Application Reference: 2025/0836

Site Address: 10 Hawthorne Way, Shafton, Barnsley, S72 8PS

Introduction: This application seeks full planning permission for the erection of detached garage to rear of dwelling

Drawing Title
PROPOSED ELEVATIONS

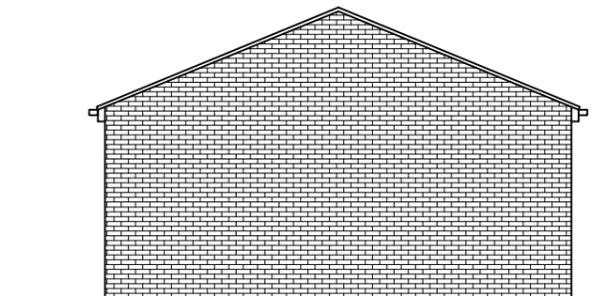
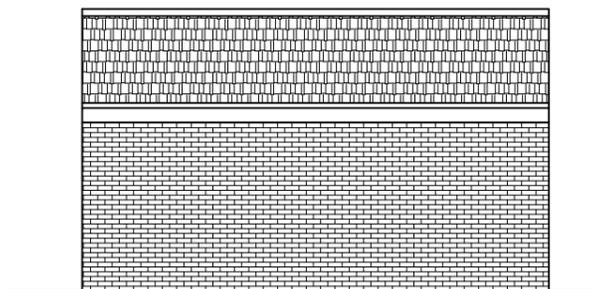
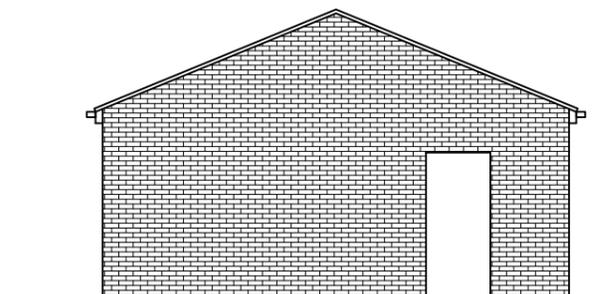
The proposed garage is approximately 6.5m x 6.5m, with a roof height of 4m to the ridge. This is in accordance with the guidelines set out in the House Extensions and Other Domestic Extensions SPD.

The proposed finish is brickwork and with roof tiles, on a gable style roof which is sympathetic to the host dwelling.

The garage is sited to the side/rear of the property and therefore will have limited impact on the character of the dwelling and street scene of Hawthorne Way. However, there may be some impact upon the street scene of Meadow Croft given its prominent location. Given there are front projections along Meadow Croft with no uniform building line the erection of the garage in this location would be acceptable in this instance.

Drawing Title
PROPOSED PLANS

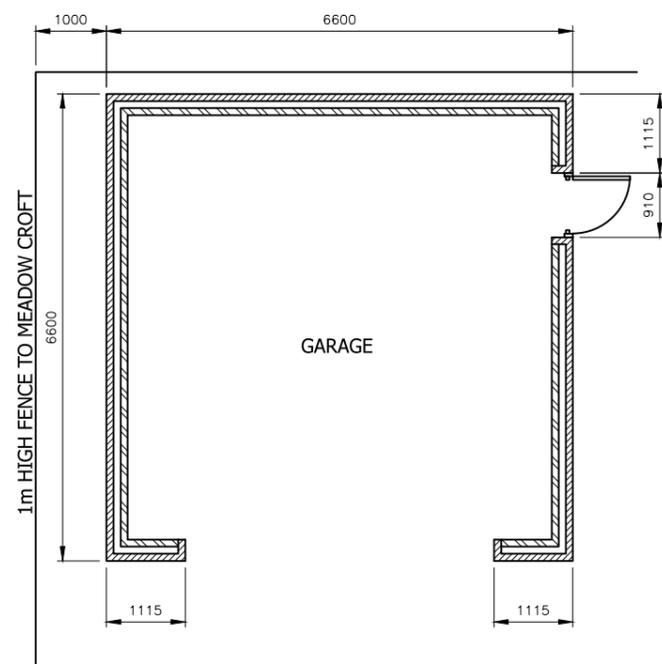
The garage is sited at the rear of the dwelling, adjacent to No2 Meadow Croft. There are no windows to the side elevation of the adjacent property or proposed garage, as such it is unlikely the proposal would cause any overlooking or overshadowing. the existing garage, it would minimise the impact of overshadowing on No2.
